# PARTIAL FIRST FLOOR PLAN

**SUMMARY OF CHANGES:**

<b>CLIENT:</b> CHRIS MUNZ	<b>PROJECT:</b> MUNZ RESIDENCE	<b>DRAWING NUMBER:</b> 1 of 3	<b>SHEET:</b> S2
---------------------------	--------------------------------	----------------------------------	---------------------

<b>CLIENT:</b> CHRIS MUNZ	<b>PROJECT:</b> MUNZ RESIDENCE	<b>DRAWING NUMBER:</b> 1 of 3	<b>SHEET:</b> S2
---------------------------	--------------------------------	-------------------------------	------------------

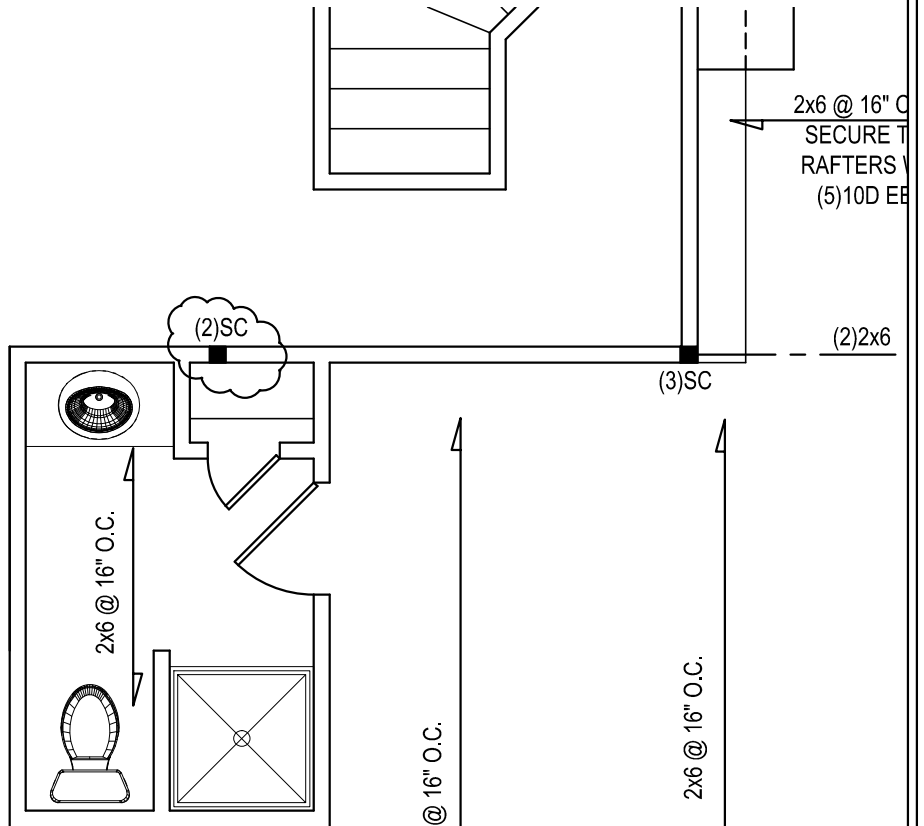
1) SUPPORTS ADDED FOR NEW POINT LOADS FROM DOUBLE RAFTERS

<b>CLIENT:</b> CHRIS MUNZ	<b>PROJECT:</b> MUNZ RESIDENCE	<b>DRAWING NUMBER:</b> 2 of 3	<b>SHEET:</b> S3
---------------------------	--------------------------------	----------------------------------	---------------------

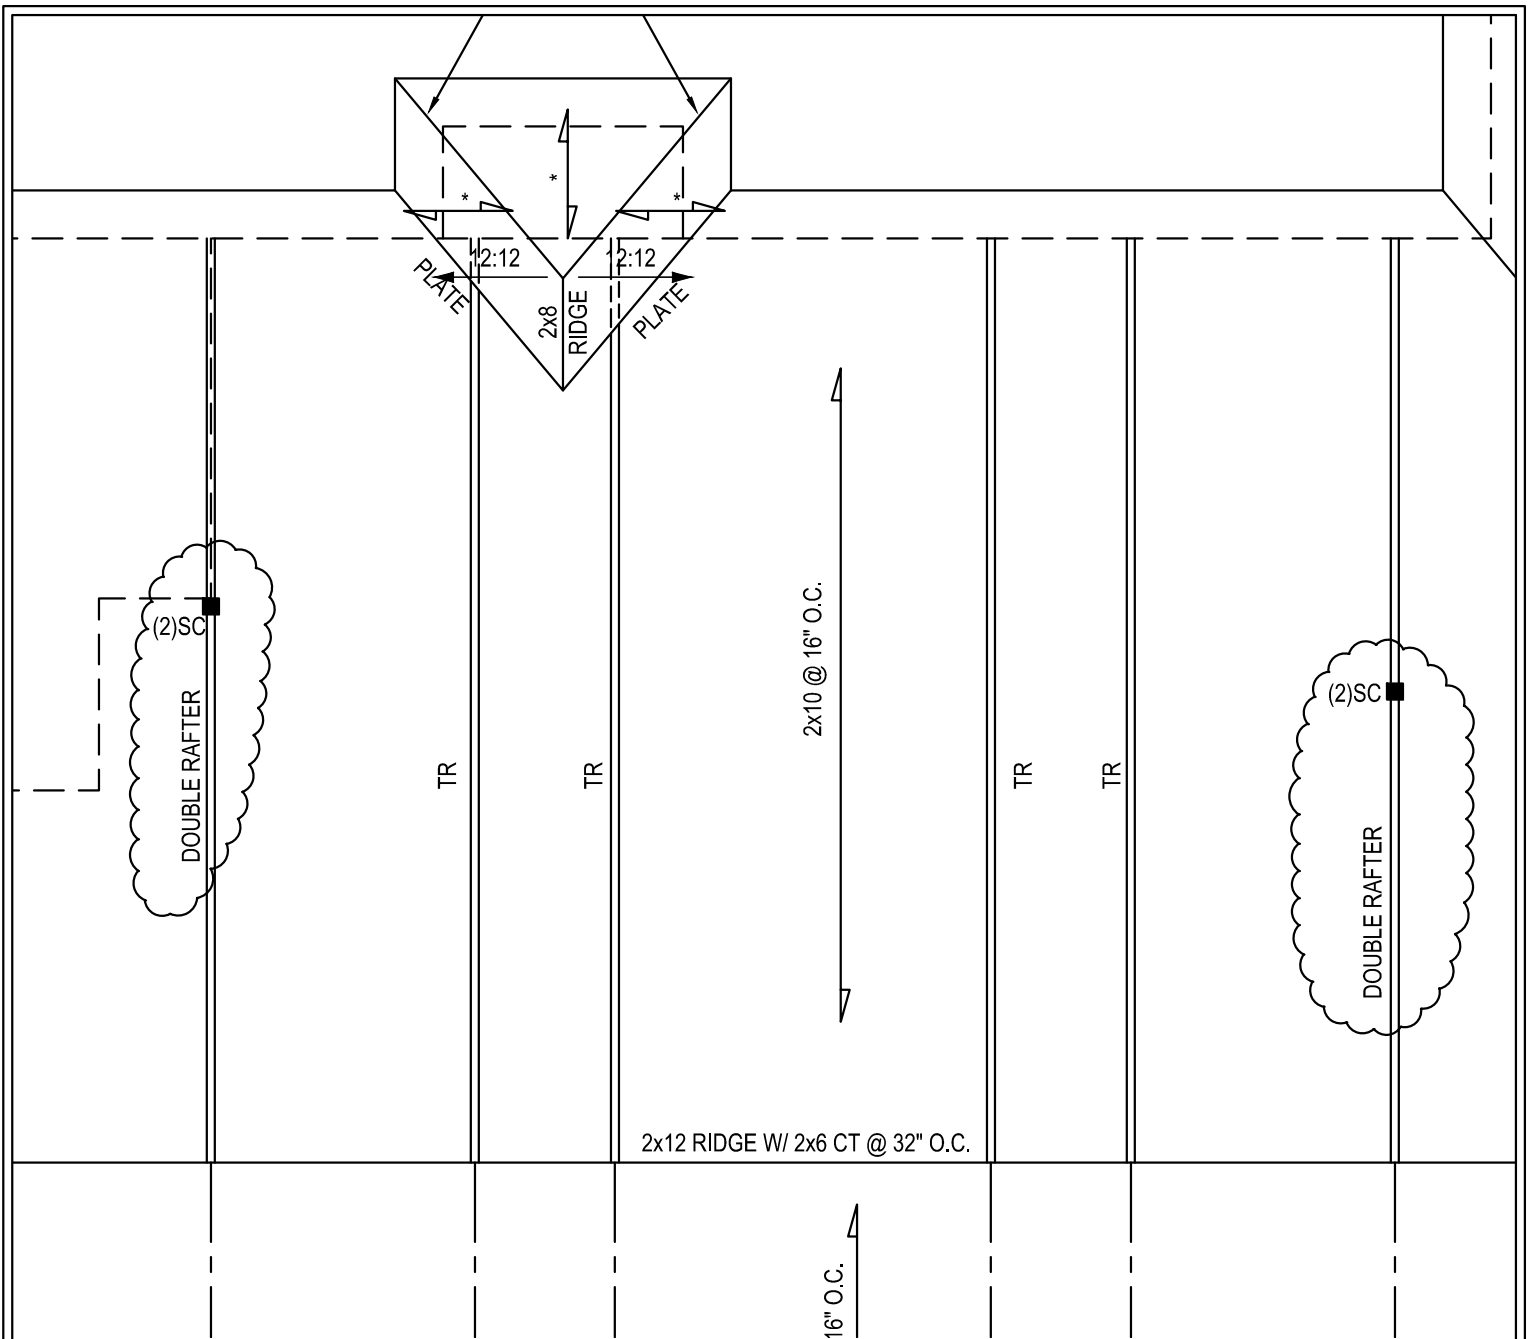
1) STUD COLUMN ADDED FOR SUPPORT OF DOUBLE RAFTER.
